Erection of front dormer to existing garage and conversion of garage to form habitable space with revised fenestration and 1no rear rooflight and associated works.

BH2020/01230

Condition 1

drawing name
Existing & Proposed
Floor Plans

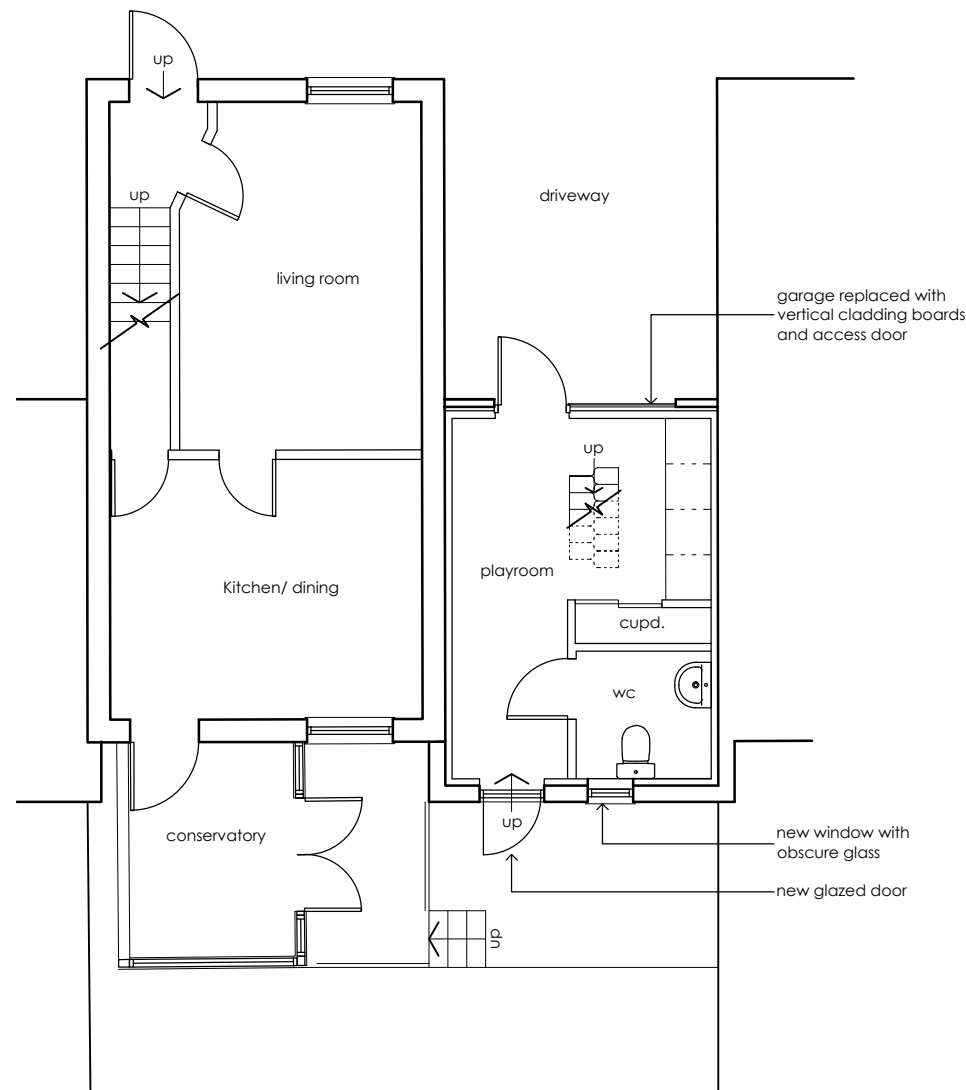
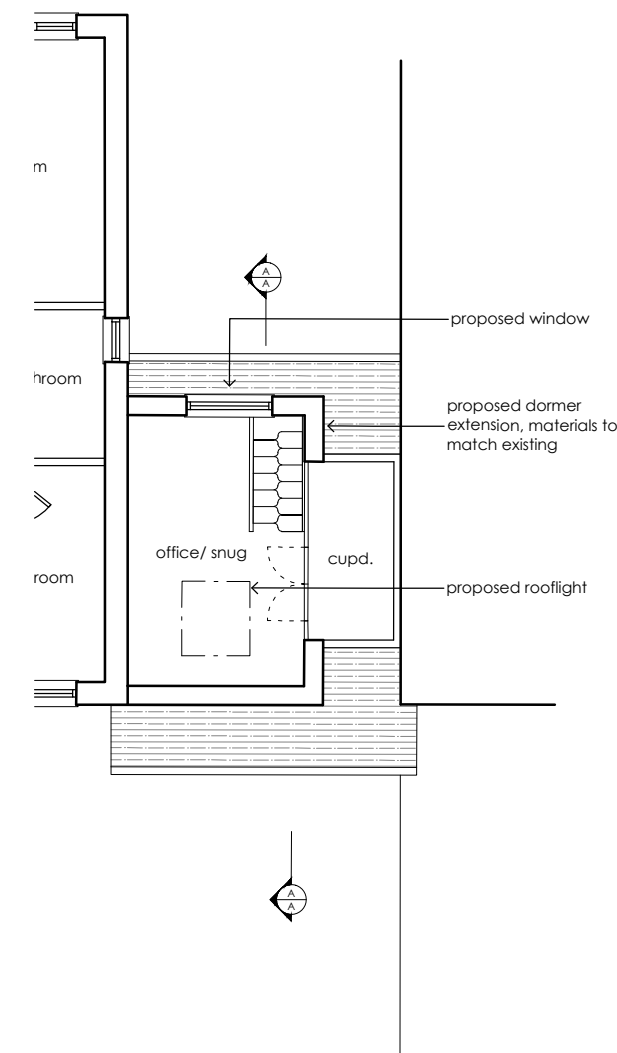
During construction it was made clear that accommodating the proposed internal door between the garage conversion and main house would not be viable due to the substantial level change. Exploration of potentially accommodating the access door at first floor was also considered but presented a similar problem as well as creating an access issue under the building regulations. These restrictions call for the installation of a conventional stair which would remove much of the usable space, and option that makes the conversion no longer viable.

In order to retain as much space as possible the best access solution is a hit-and-miss stair as originally proposed. Our main concern is that the works are almost complete but cannot obtain building control approval unless the access door is removed.

Our request would be to have these replaced with plans without a door between the main house and garage conversion. The door was an amendment made to the original application in response to neighbours' concerns about a potential sub-division of the garage. As the intention is not to have the space sub-divided, we suggest an additional condition be added to the approval, one that specifically prohibits the sub-division of the garage from the main house.
